Drainage Assessment - Event Parking Area.

50 Peter Brock Drive, Eastern Creek,
NSW

P2108122JR02V01

April 2021

BIOFILTRATION DETAIL
NOT TO SCALE

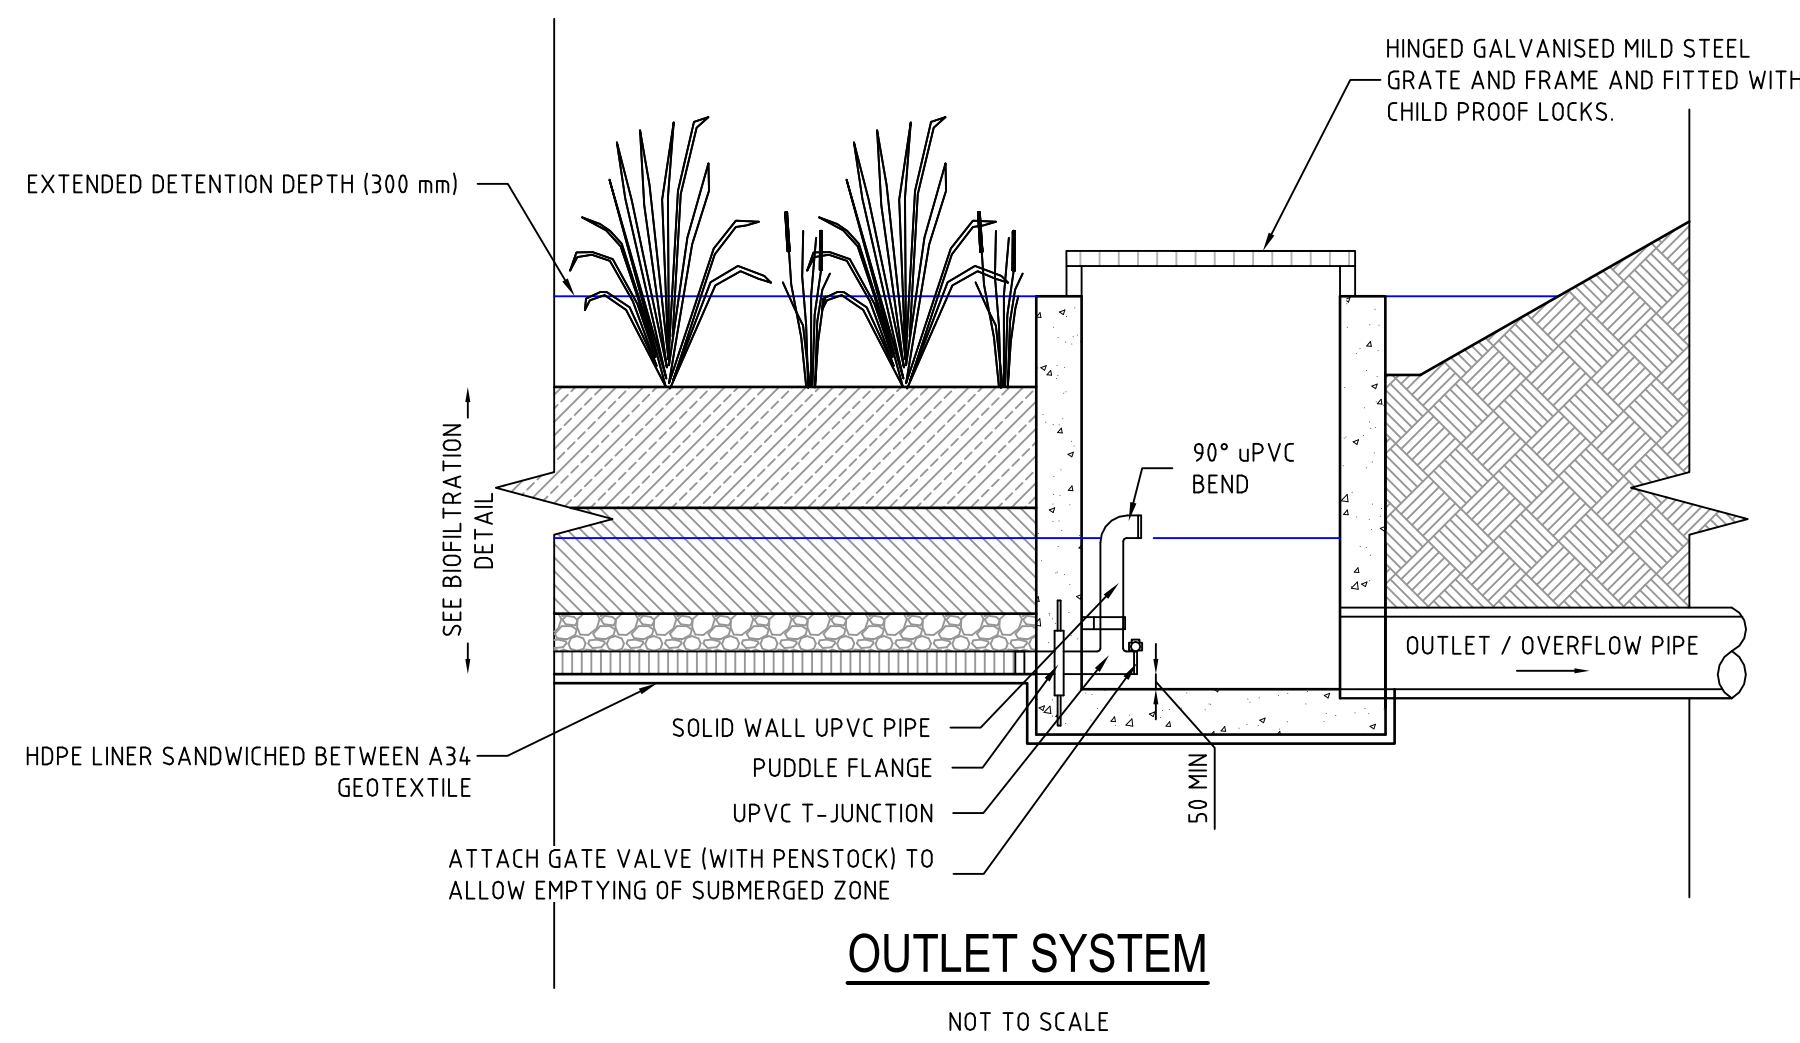
7.5 Water Quality <i>Having regard to changes in surface finish, a water quality treatment system is to be designed by the Engineer in accordance with Council's MUSIC water quality conceptualisation model and submitted for further consideration.</i>	A water quality system is included within the design of the drainage system for Event Parking Area in accordance with BCC's MUSIC guidelines to treat the pollution generated from the changes in surface finished proposed by the development. Refer to Section 2 for further details.

A bioretention basin is proposed for the site, providing tertiary treatment removing pollutants via filtration, adsorption and biological uptake. Refer to MA planset P2108122PS01 drawing PS01-E100 for the basin location and drawing PS01-E201 for basin details.

DRAWING TITLE DRAINAGE DETAILS SHEET 3				
PROJECT NO.	PLANSET NO.	RELEASE NO.	DRAWING NO.	REVISION
P2108122	PS01	R03	PS01-E202	B

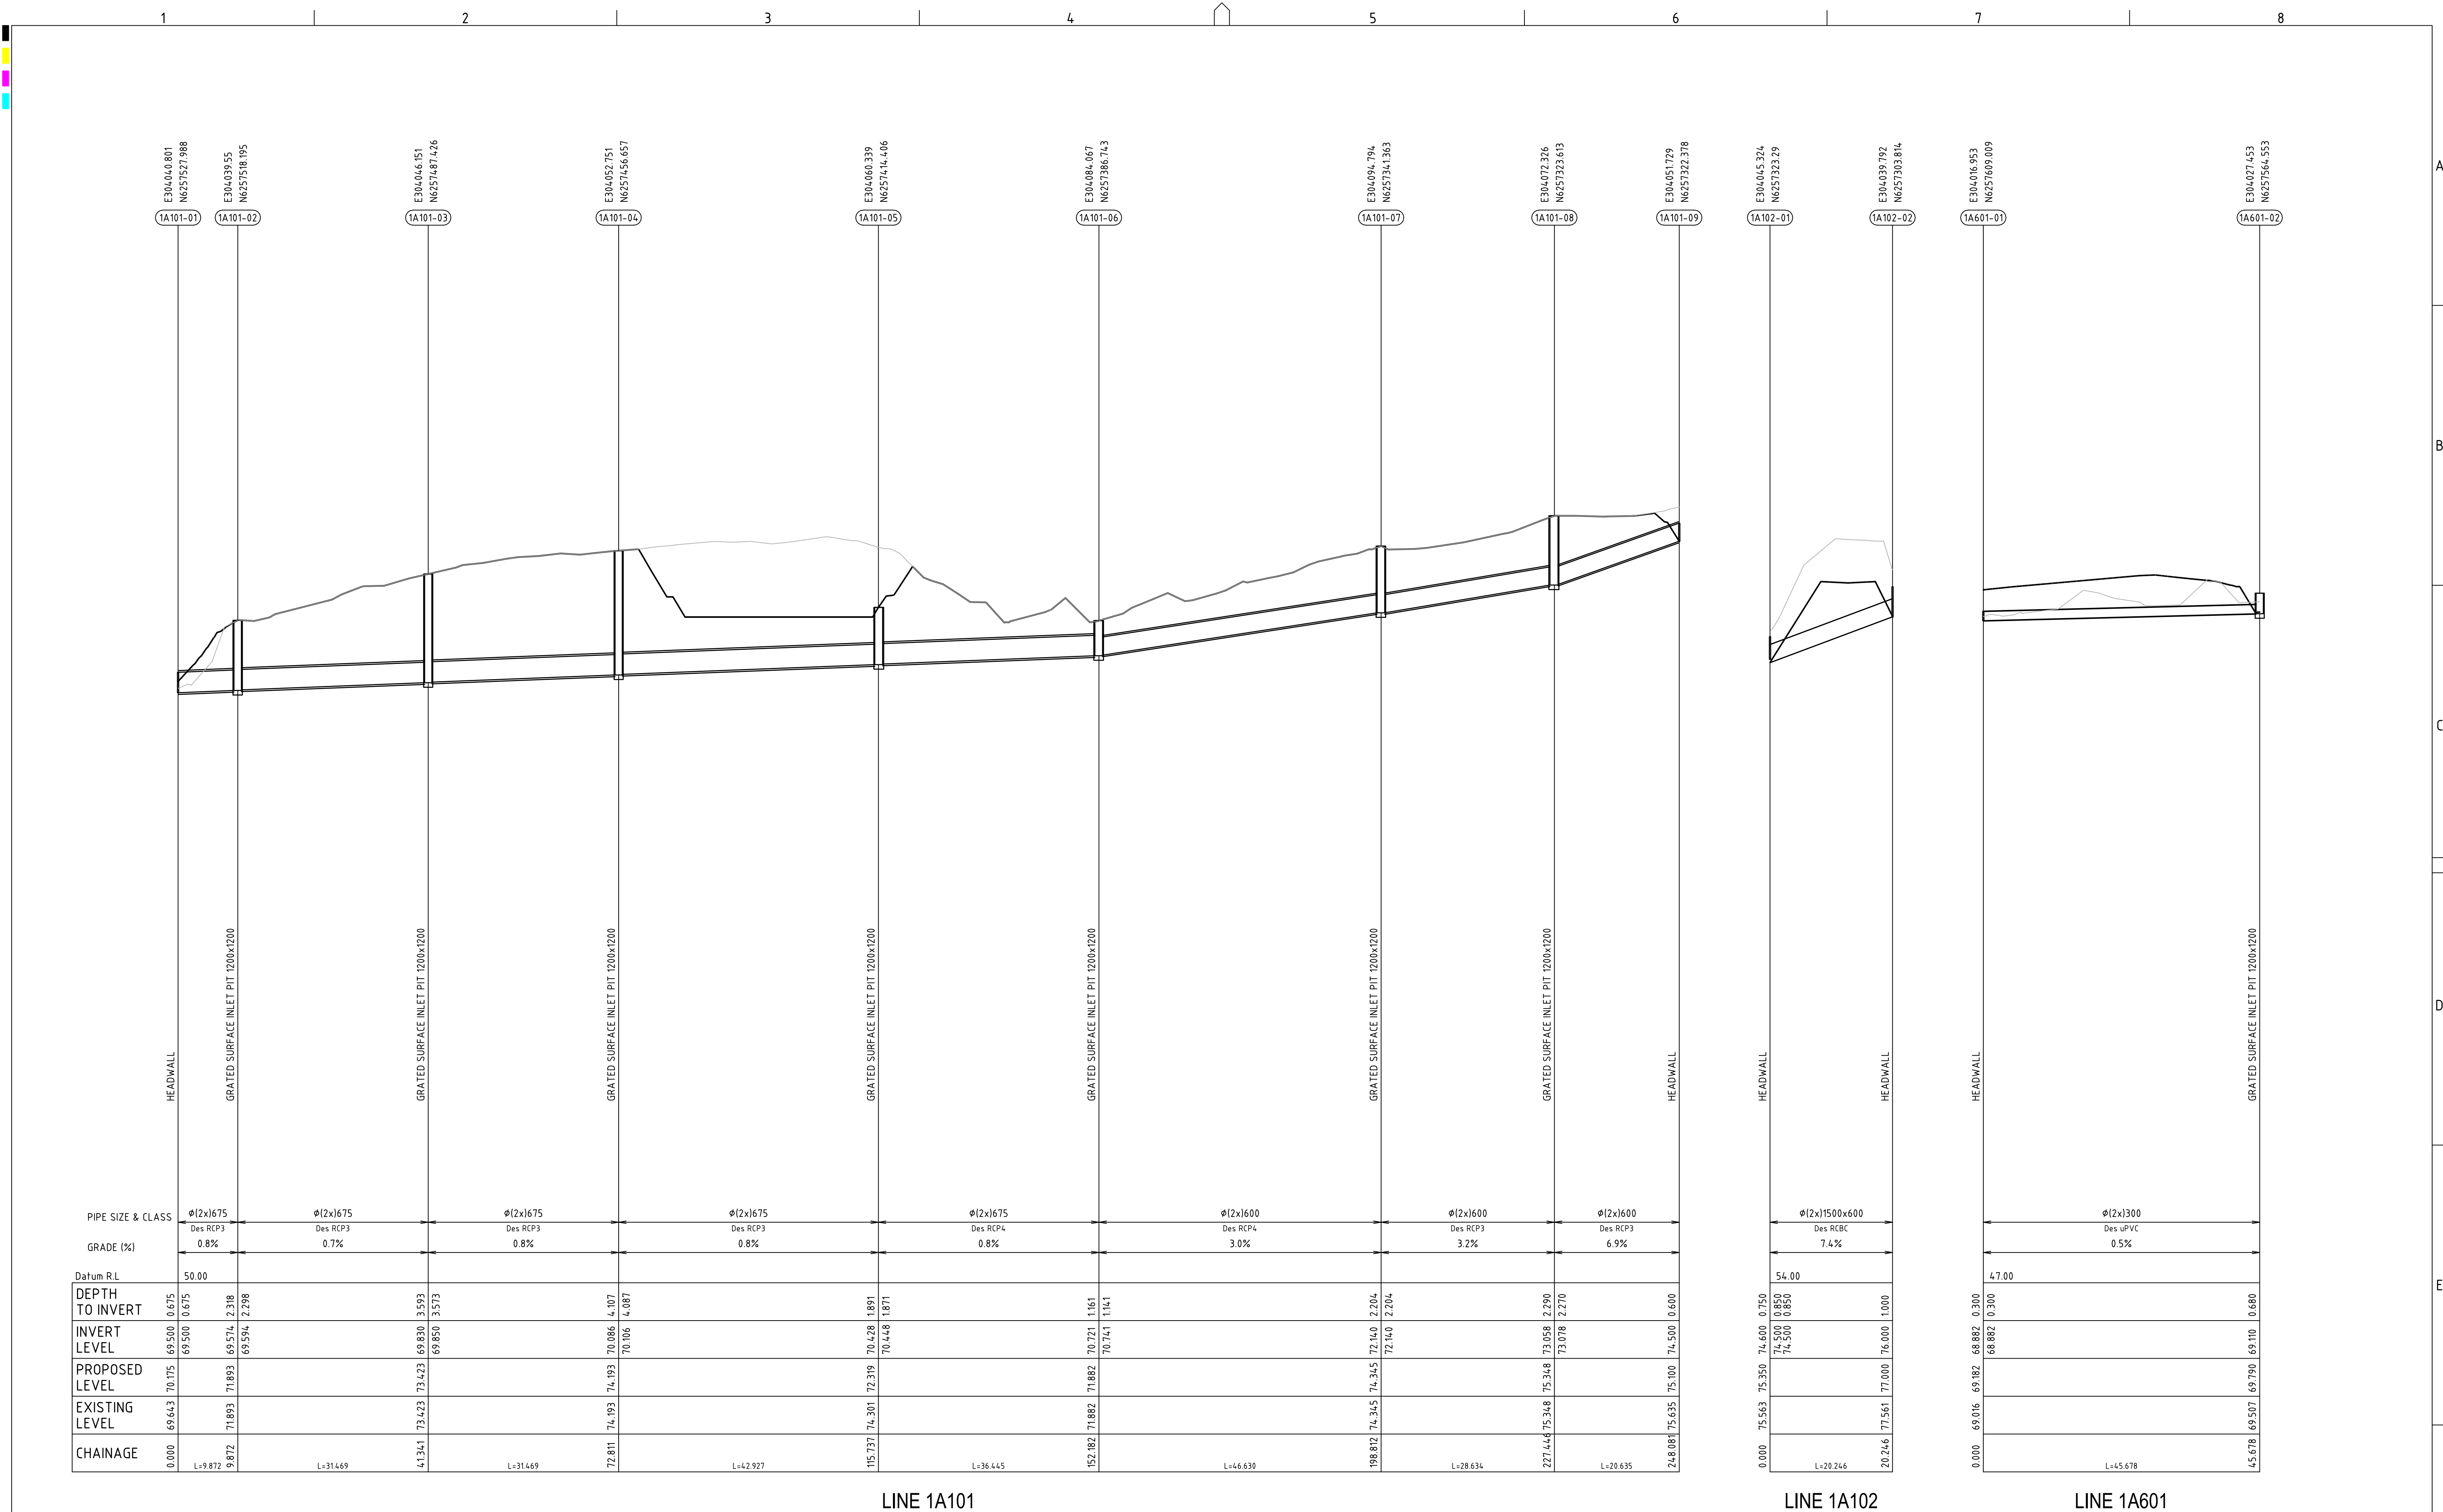
RFI Issue	Response / Comment
7.2 Eastern Swale <i>Submissions appear to show the eastern side batter of the fill work is graded directly to the existing level on the common boundary and/or very overgrown, impacting on its runoff carrying capacity. In this regard, please provide hydrologic calculations for the 100 year average recurrence interval (ARI) stormflow to the swale on the common boundary with No. 10 Raceway Place to ensure safe disposal with event parking overland drainage systems directed to the west. Provide channel calculations to indicate design flow velocity, depth and width at the most conservative chainage. Provide 500 mm freeboard between the design flow water level and existing surface level on the common boundary.</i> <i>Design a swale at appropriate scale showing how the swale design matches with existing levels. Levels and batter grades for the existing and post-development case must be shown. Where a swale is proposed to be traversed by a design vehicle (which may be a commercial service vehicle or an Endeavour Energy designated vehicle), provide a longitudinal section through the traverse and using an appropriate guideline such as AS 2890.2 :2002 Section 3.3.3 show how the design vehicle avoids scraping.</i>	The catchment area to the swale has been reduced and does not form a key element of the design as upslope flows are conveyed within the central drainage line through the site. Flow calculations are detailed in plan PS01-E202 (refer also to section 2.2). Freeboard is in accordance with BCC requirements for minor drainage systems. Detailed levels for the swale are provided in the civil plans.

1. The swale catchment consists only of the carpark fill batter to the west and does not receive any upstream flows. In doing so, only very small quantities of water are contained and passed through the swale.
2. The swale has maximum internal batter slopes at 1 in 3 and a top width of 1 m.

3. The capacity of the swale has been sized to convey the 1% AEP flow.

Swale details and calculations are provided in Attachment D drawing PS01-E202.
